DETERMINATION OF SILO STRENGTHENING WORKS, GLEBE ISLAND

MAJOR PROJECT NO. 05_0060

**SILO STRENGTHENING WORKS, LOT 1, SOMMERVILLE ROAD, GLEBE
ISLAND**

Drawing No. IS 004 Rev. 03

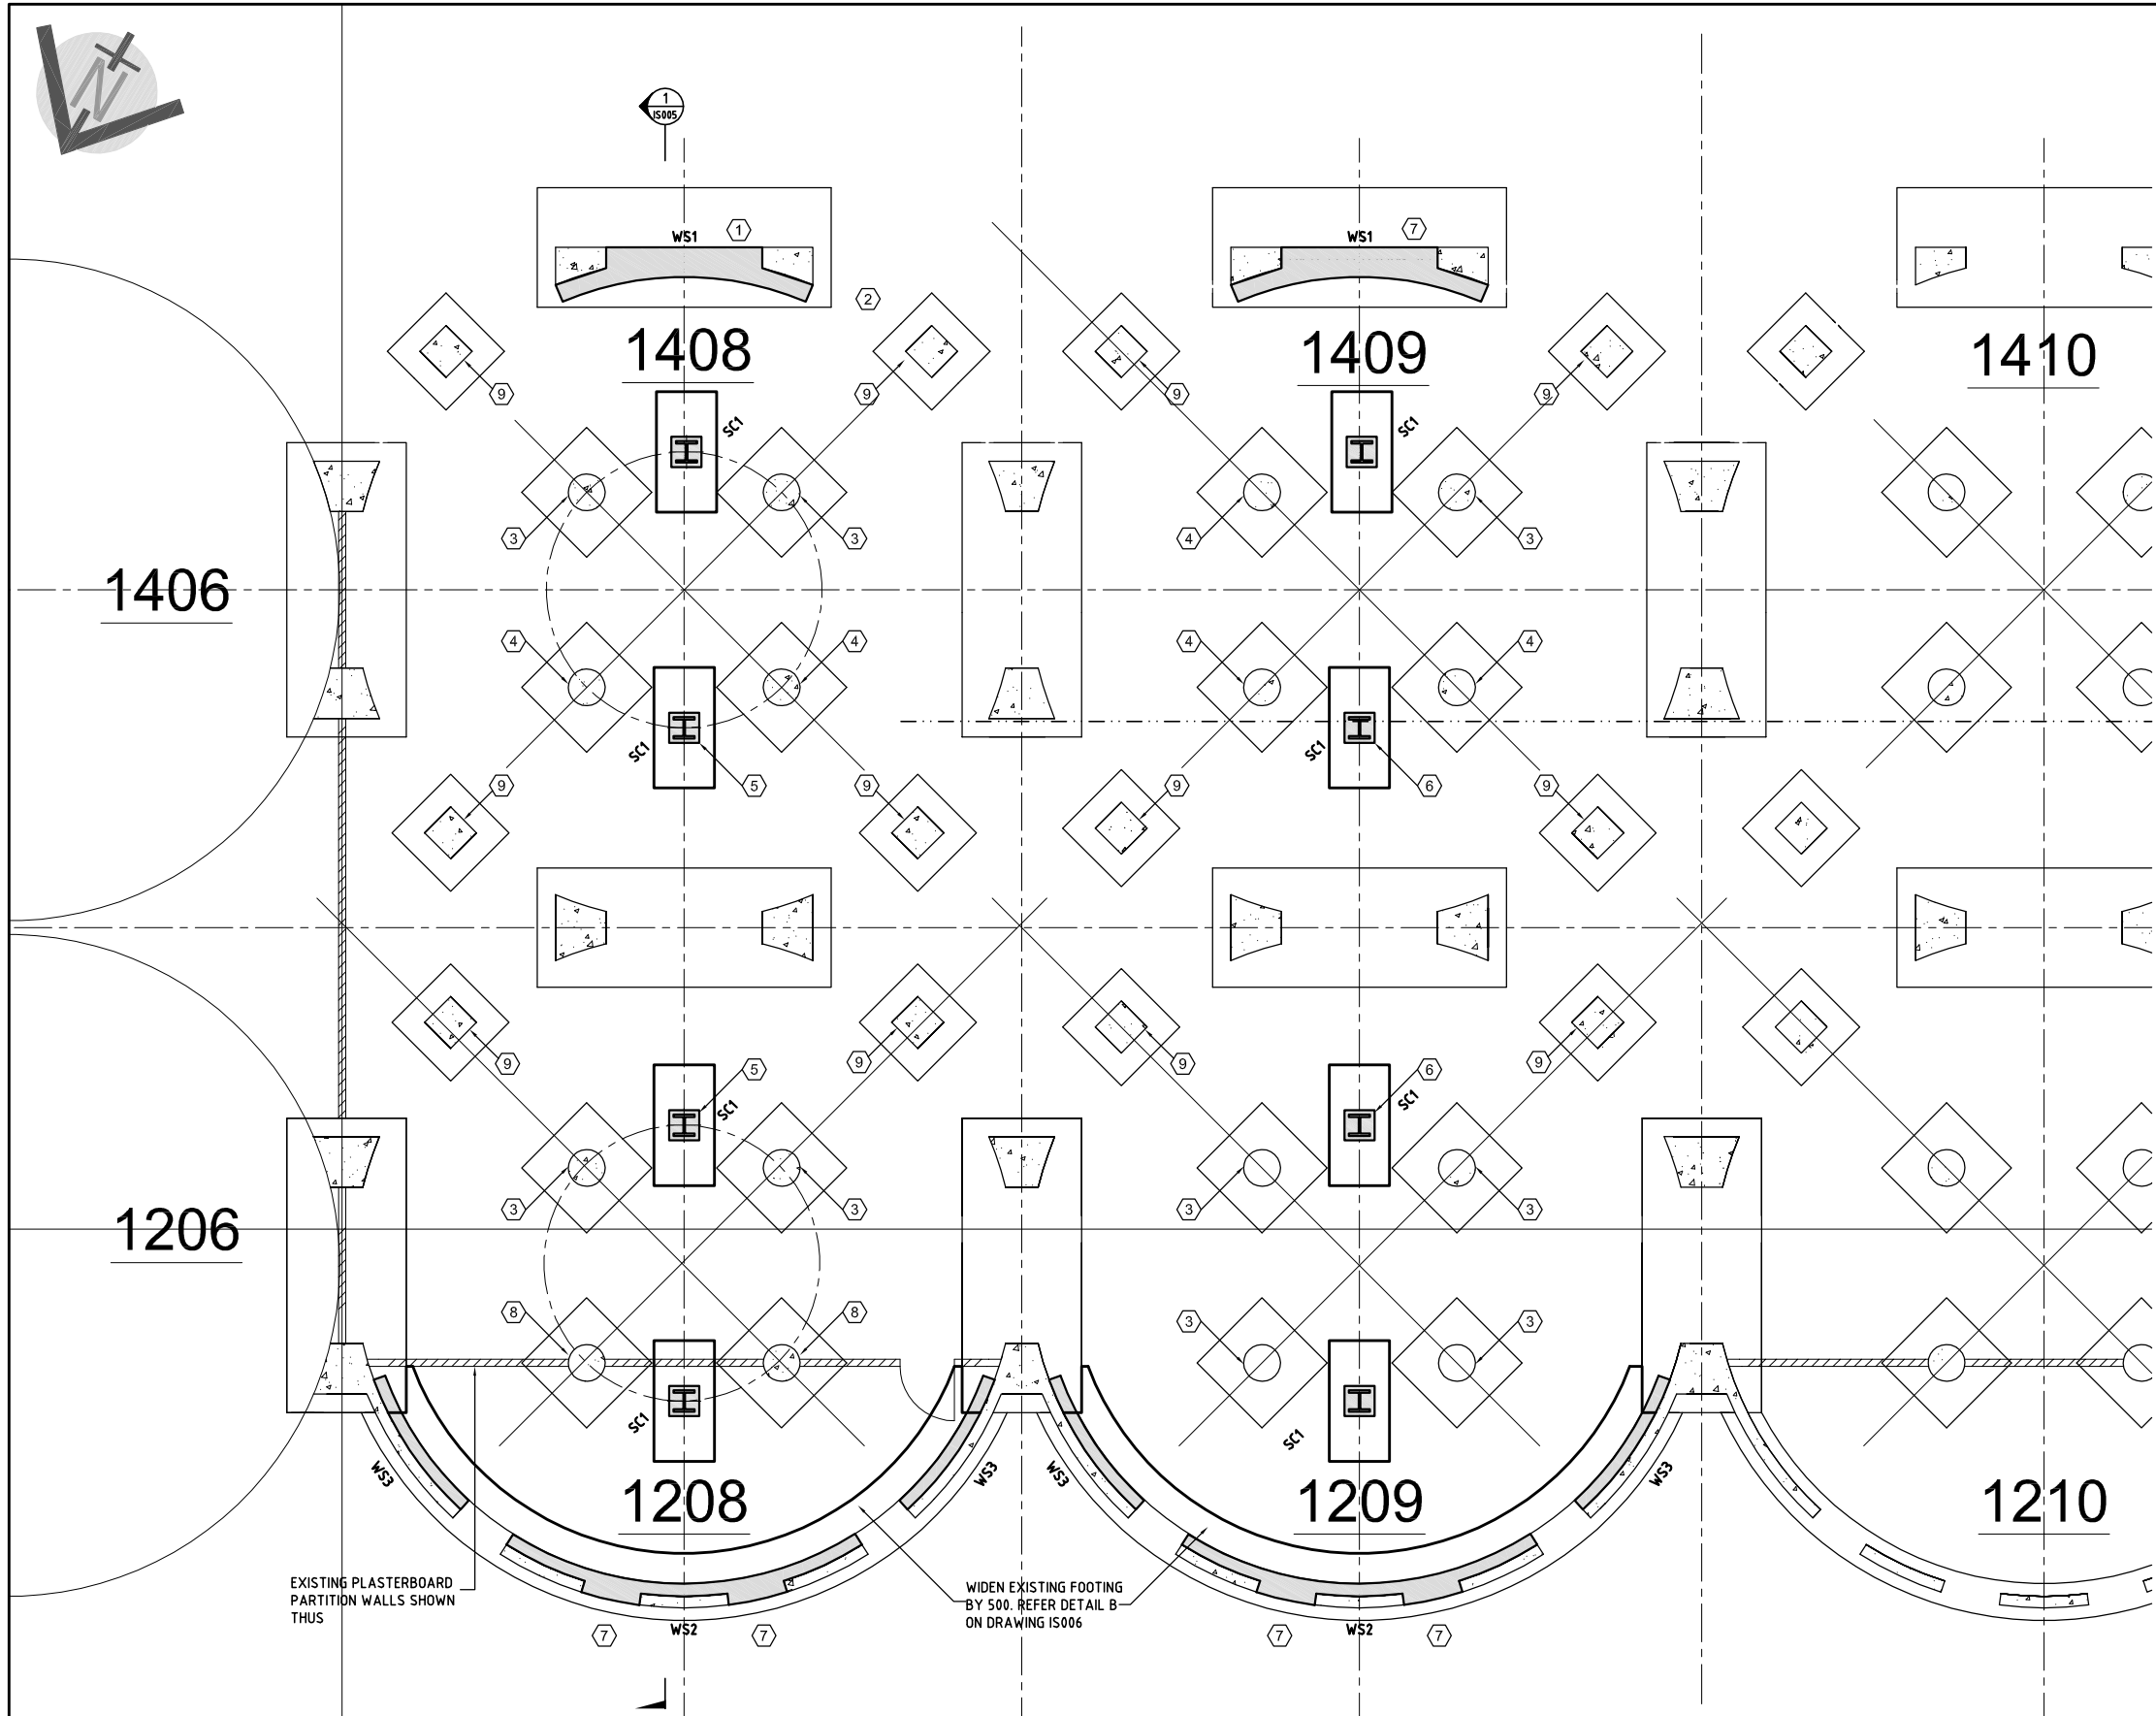
The infilling of the windows shall be undertaken in a manner that is complimentary to the concrete colour of the base of the silos. The infilling of the windows must still enable the original form of the windows to be interpreted and read. The Applicant shall submit to the satisfaction of the Department the proposed method of delineation prior to the commencement of works.
